WELWYN HATFIELD COUNCIL – DEVELOPMENT CONTROL
DELEGATED REPORT

APPLICATION No:	S6/2012/0479/FP
APPLICATION Site:	33 Kentish Lane

Existing Elevations

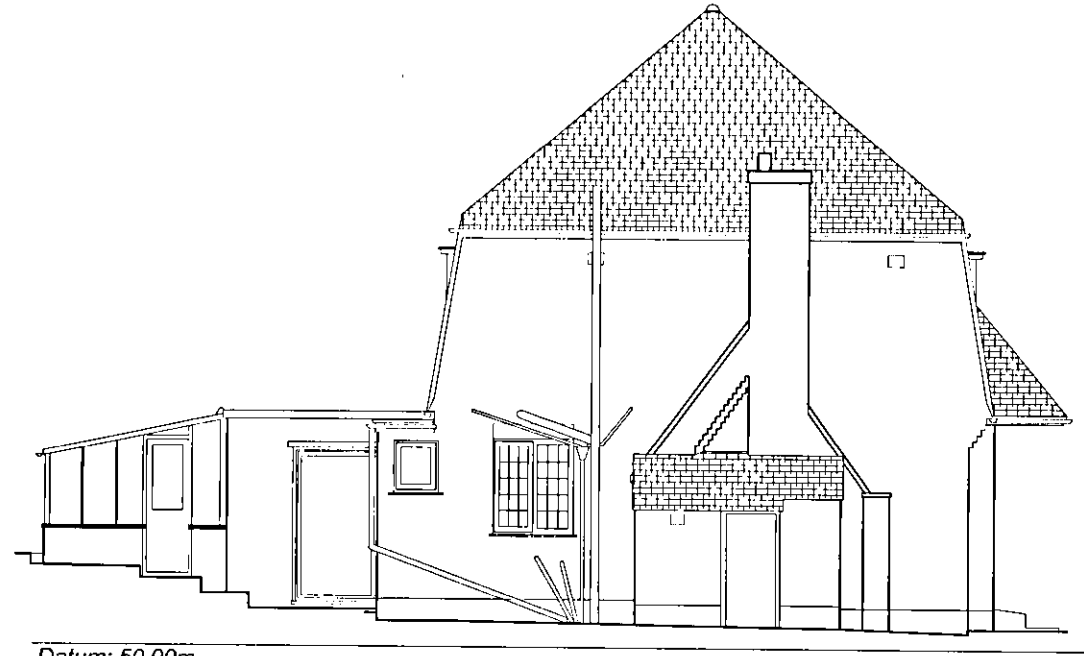
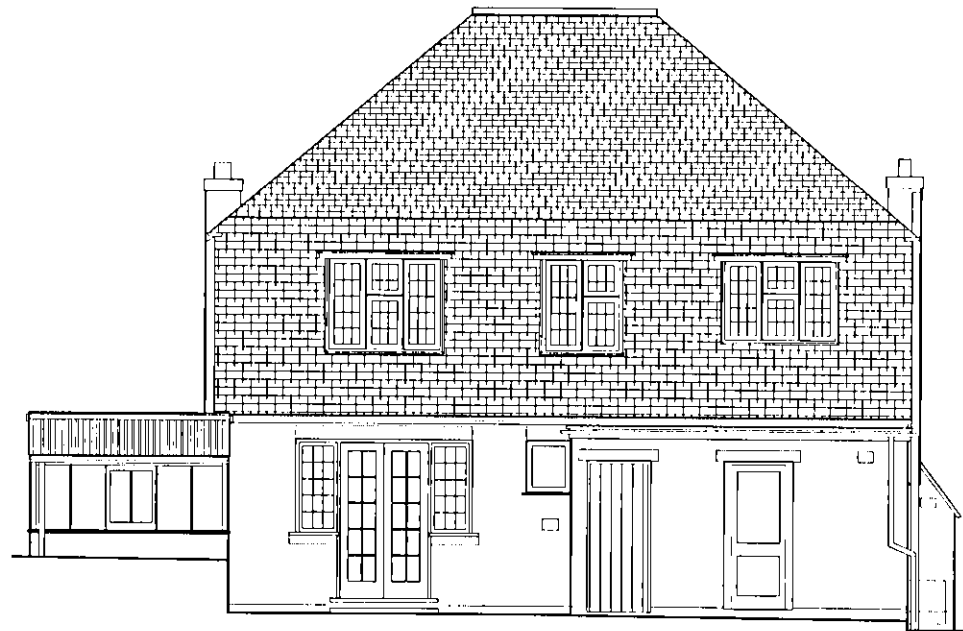
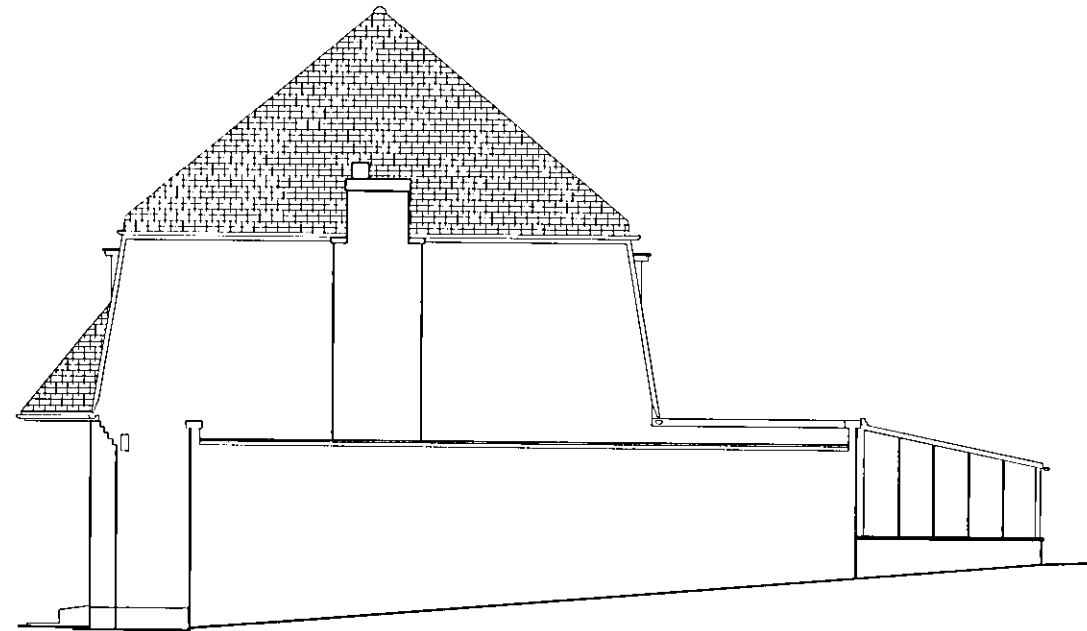
The gambrel roof of the existing dwelling has low eaves across the front and rear of the building, extending to ground floor level and measuring approximately 2.8m in height. The replacement dwelling has been designed to appear as a ‘true’ two storey building with additional accommodation within the roof space. The resulting eaves would measure approximately 5.7m in height. In terms of overall height, the crown roof of the replacement dwelling would measure approximately 8.9m in height exceeding the height of the existing dwelling by 0.5m.

The replacement dwelling would be clearly visible from the site frontage with Kentish Lane. In particular, the increase in bulk and massing at a high level would result in more prominent structure than the existing dwelling and a reduction in the openness of its immediate surroundings. The proposed replacement dwelling would have a front elevation that is both wider and taller than the existing dwelling to be demolished. The height of the eaves would increase from approximately 2.8m to 5.7m and the ridge line would increase in width from approximately 2.5m to approximately 6.6m emphasising the additional bulk within the roofspace.

Existing First Floor Plan
Existing Roof Plan

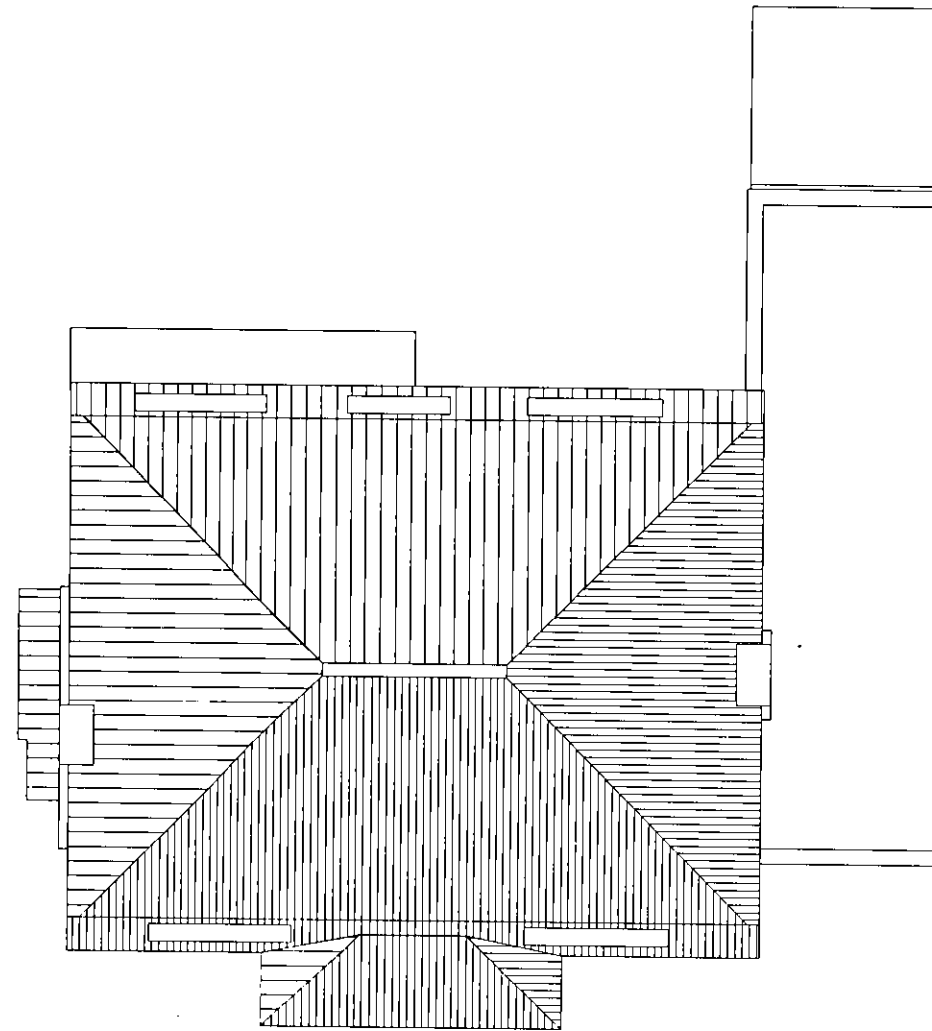
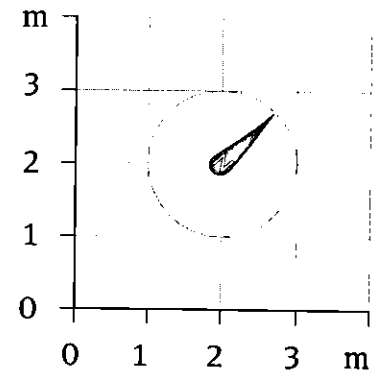
Drawings of the existing dwelling have been submitted as part of this full planning application and measurements have been taken from these in calculating the floorspace and footprint figures. The floorspace of the existing dwelling (including the garage) measures approximately 167sqm. The floorspace of the proposed dwelling would measure approximately 409sqm equivalent to a 145 percent increase over-and-above the existing dwelling. In terms of footprint, the existing dwelling measures approximately 100sqm and the proposed 190sqm equivalent to a 90 percent increase over-and-above existing.

Revision _____
 Project title
 33 Kentish Lane
 Brookmans Park
 Hatfield
 Drawing title
 Topographical Survey -
 Root Protection Area
 Client
 Antonis Antoniadis
 Scale
 1:200 @ A3
 Date
 February 2011
 Drg. no.
 1111 98 500

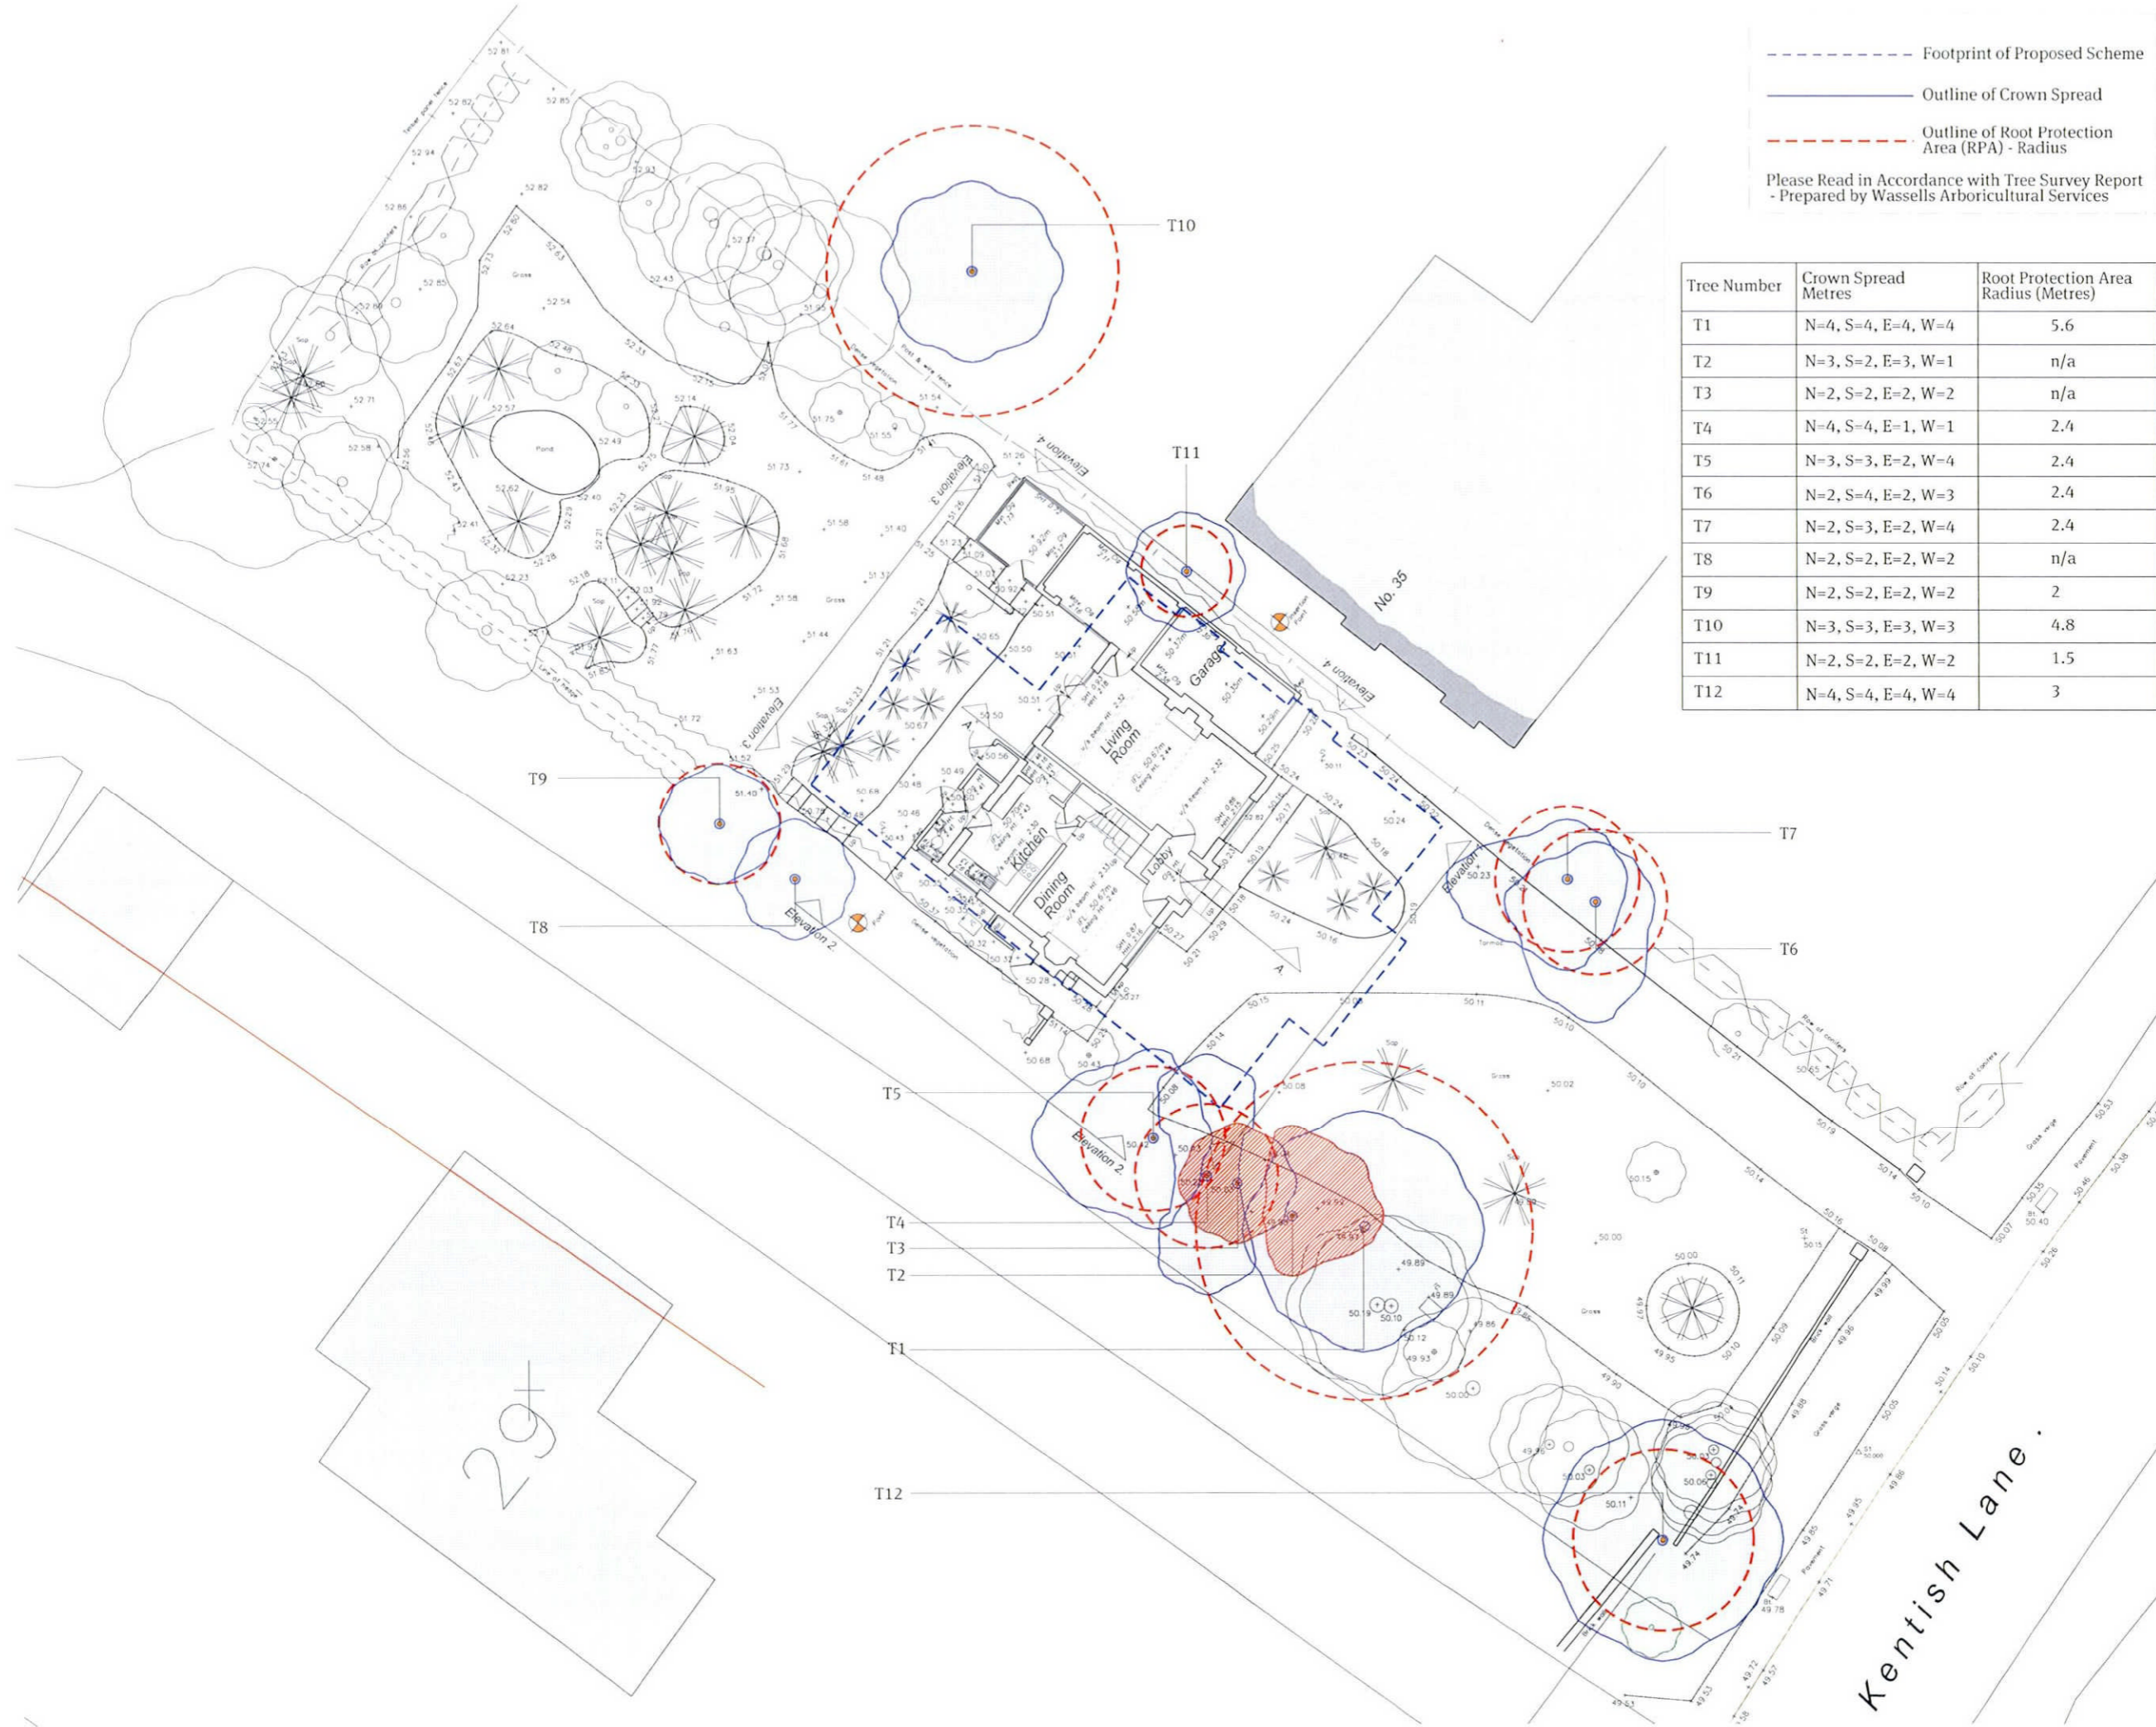
Impact on Trees: There are several established trees within the vicinity of the proposed dwelling. Although these trees have some amenity value, they are not protected by a tree preservation order. Should planning permission be granted, a condition should be attached to ensure retained trees would be protected with fencing compliant with BS5837:2012 Trees in Relation to Construction. It would be reasonable to attach a planning condition requiring a landscaping scheme to be submitted and approved by the Local Planning Authority in order to reduce the visual and environmental impacts of the development. A landscaping scheme would include means of enclosure and boundary treatments, hard surfacing and planting plans.
